ISSUE	RESPONSE
Sydney Olympic Park Authority	
<p>SOPA Act & Environmental Guidelines</p> <p>The application does not include any assessment of consistency with the SOPA Act 2001 or SOPA's Environmental Guidelines. The SOPA Act (s22(2)) requires that <i>'in determining an application for consent to carry out development on land within Sydney Olympic Park, the Minister for Urban Affairs and Planning must consider the consistency of the proposed development with the Environmental Guidelines'</i>.</p>	<p>The Addendum to SOPA's submission identifies the relevant clauses of the Environmental Guidelines. these are addressed in the Addendum - Stormwater section of this table.</p>
<p>Stormwater</p> <p>The proposed development site is outside the WRAMS catchment area, and stormwater from this site cannot be readily harvested into WRAMS, however no other solution to stormwater collection and recycling (e.g. harvesting for reuse with the development) appears to have been considered in project design. All stormwater is proposed to be discharged to Bennelong Pond, and this is considered to be inconsistent with the Environmental Guidelines (Refer to Point 1 of the Addendum).</p> <p>Stormwater har

1 Lower Level 'The Chase'
1:100

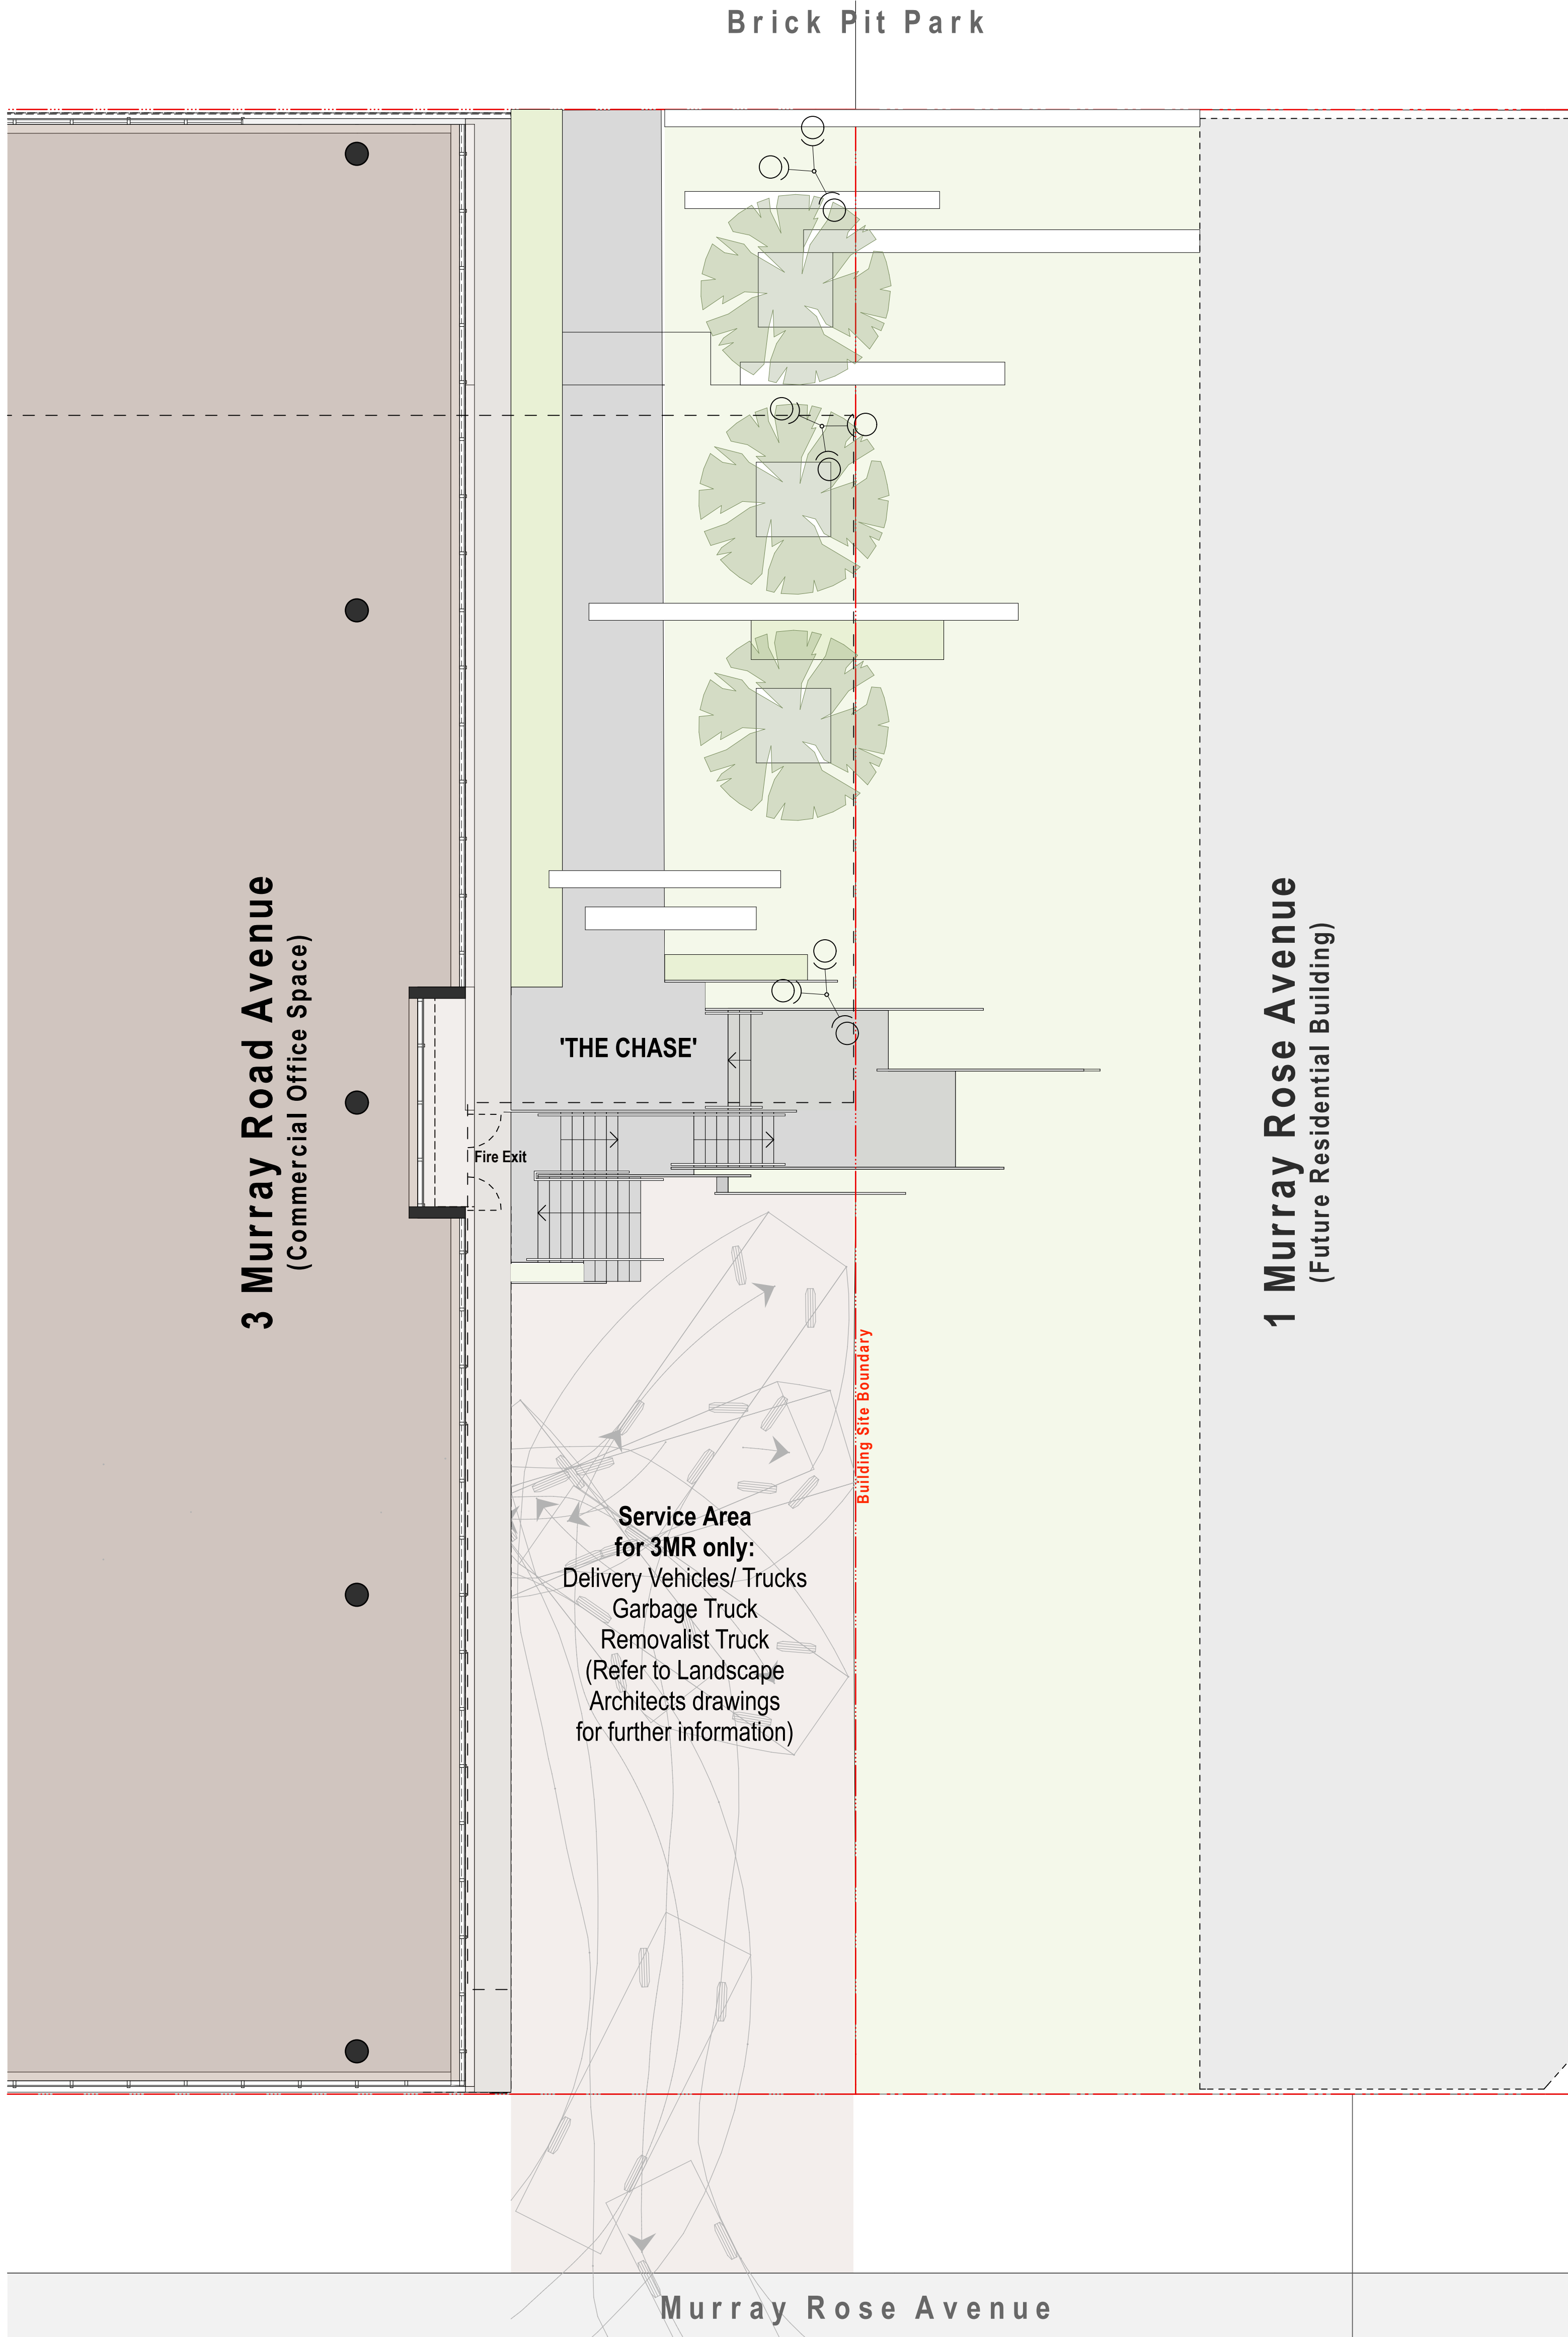
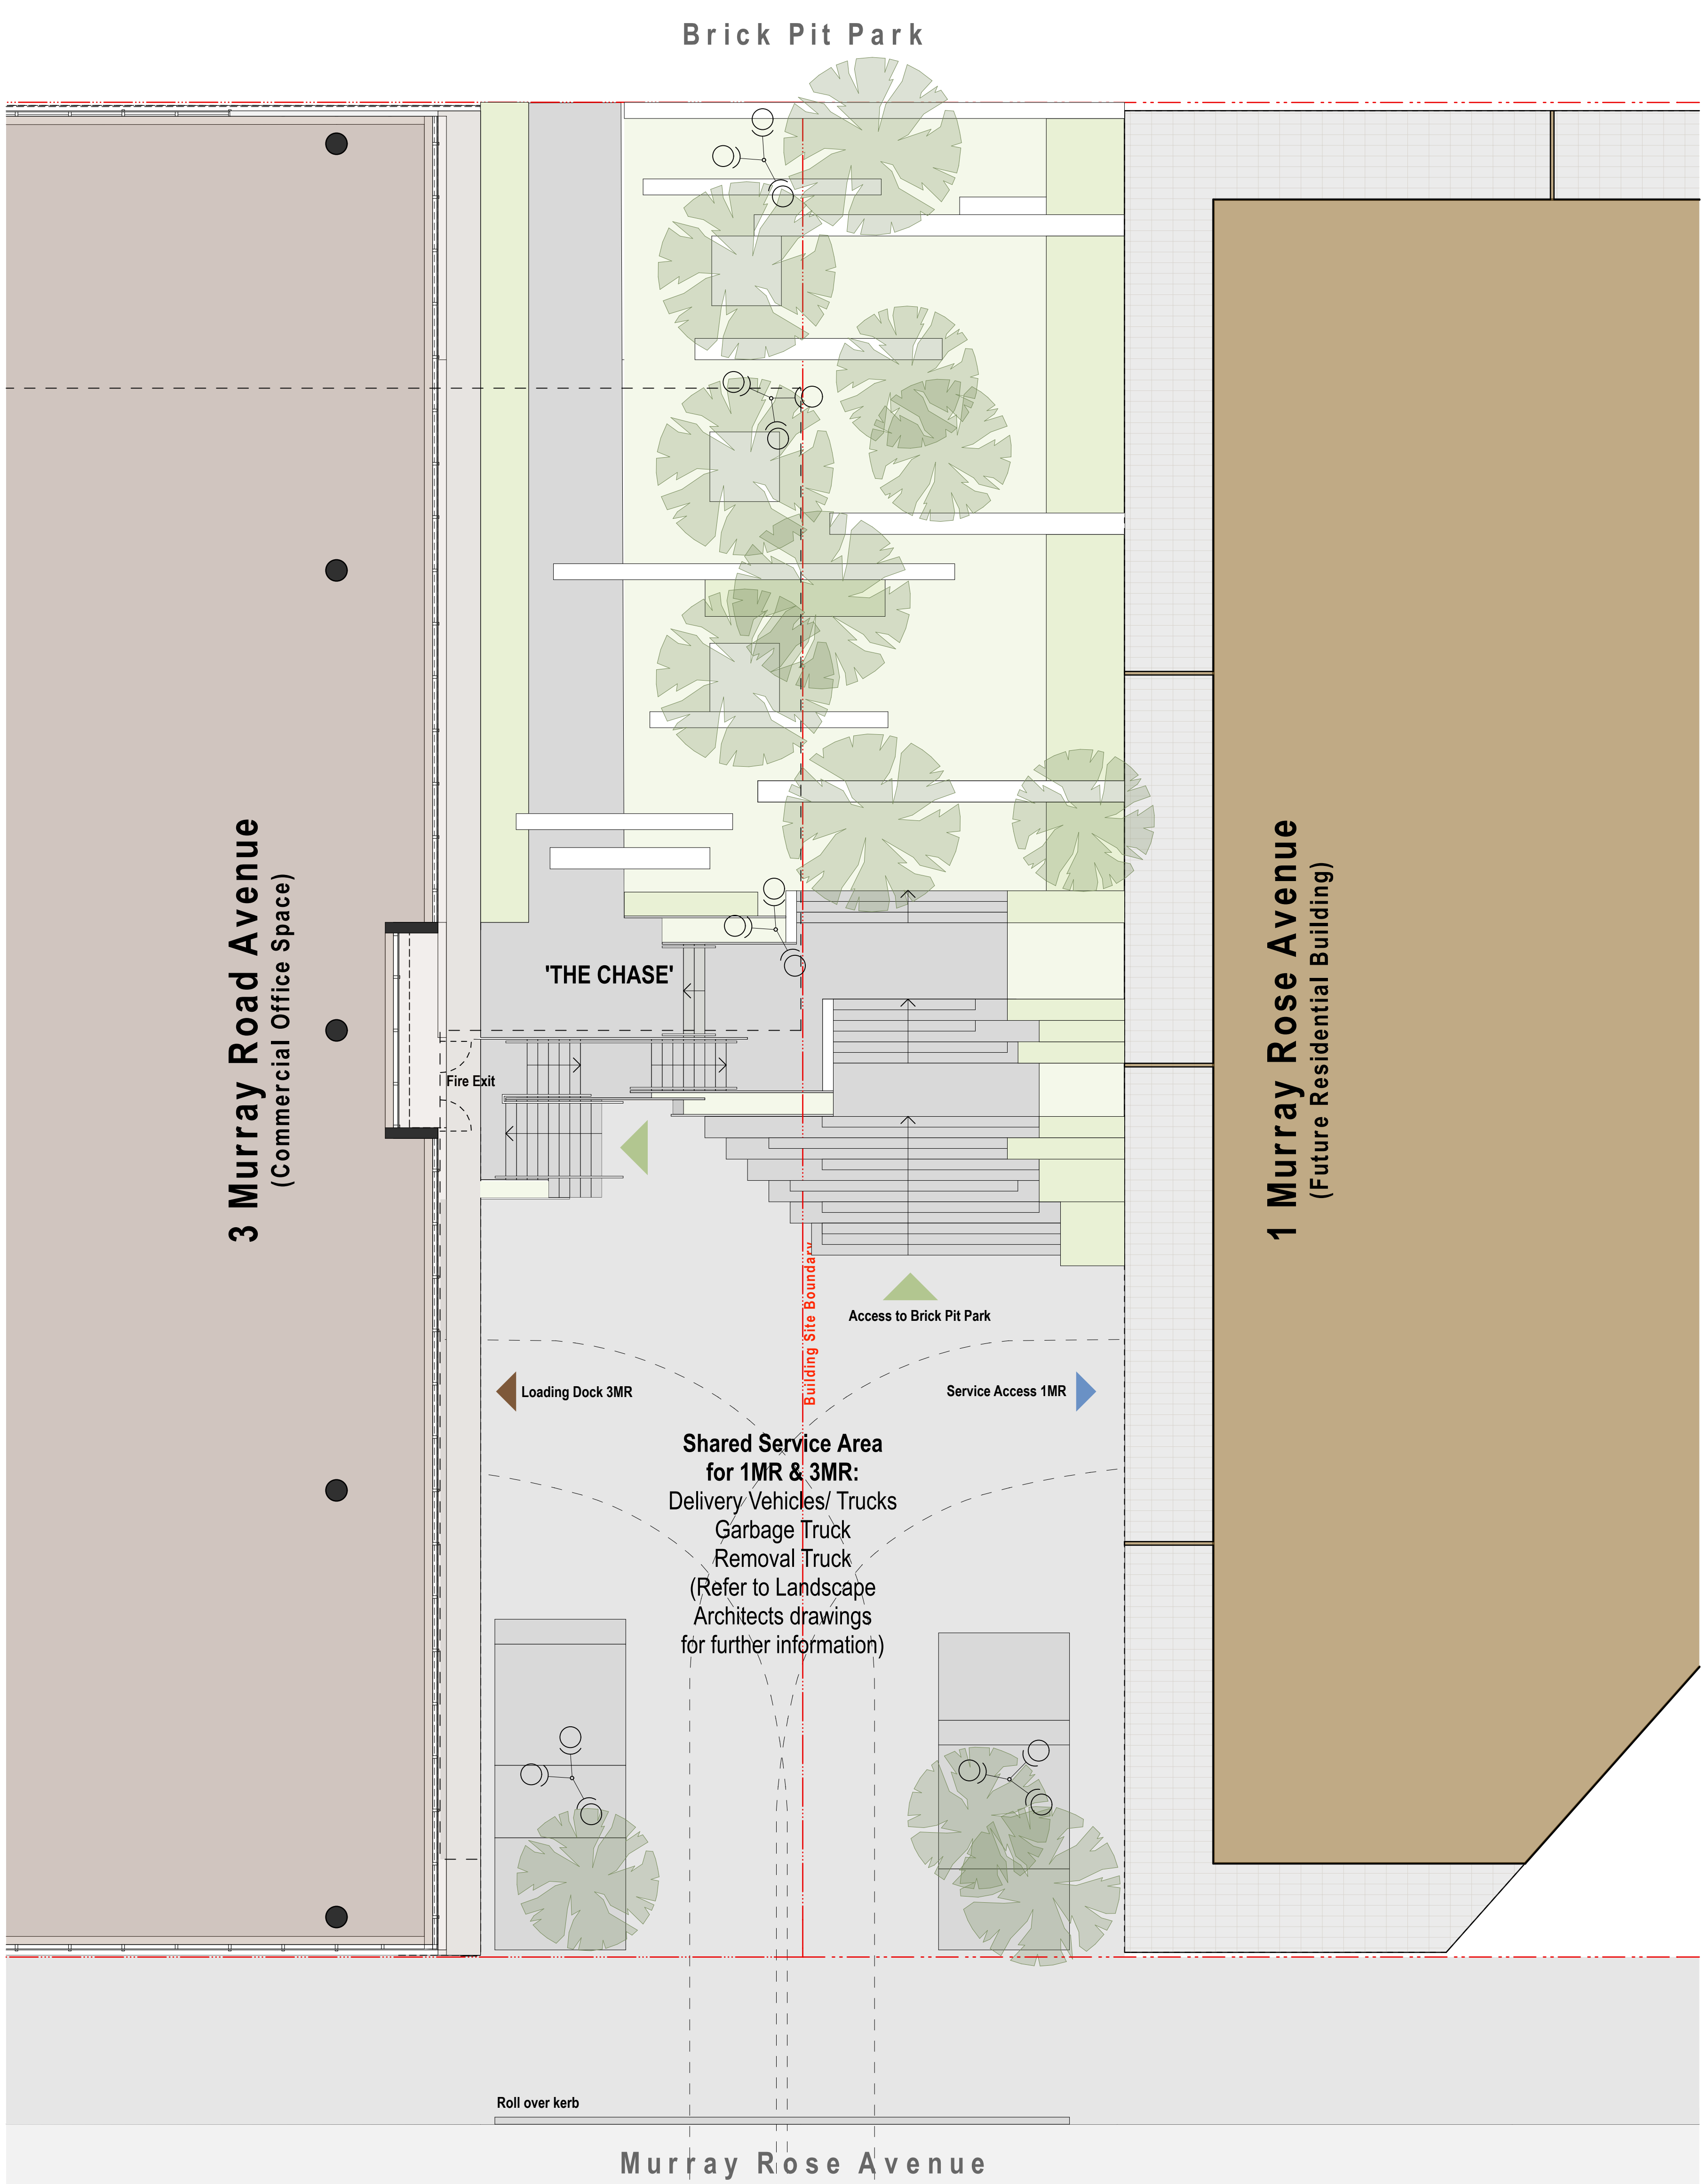
ISSUE	RESPONSE
<p>this matter in more detail.</p> <ul style="list-style-type: none"> The pedestrian path within "the Chase" is shown as 1.2m wide and not consistent with the Authority's Access Guidelines which nominate 1.8m as the minimum width for publicly accessible paths. The SOPA Access Guidelines (May 2011) are to be Implemented as the minimum standard. It is not clear if there is provision for deep soil zones / pockets to support trees proposed over "the Cutting". This is also applicable to trees proposed within "the Chase" as Drawing EA301.G indicates a plant room/service zone under the roadway with no allowance for deep soil zones/pockets to support future tree planting shown on Drawing LA6D. The proponent should prepare a Landscape Plan with cross sections (showing minimum 1m depth tree planting pockets, root-able soil volumes and irrigation system) for SOPA's approval. 	<p>SOPA Access Guidelines.</p> <p>Deep soil zones are provided in the area adjacent to Murray rose Avenue in the Cutting and adjacent to Brick Pit Park in the Chase. These are not over any structure and so will be able to support large trees. The planting near Murray Rose Avenue in the Chase is nominated on the landscape drawings as "stepped entry planting accentuating laneway design" and does not require deep soil zones.</p>
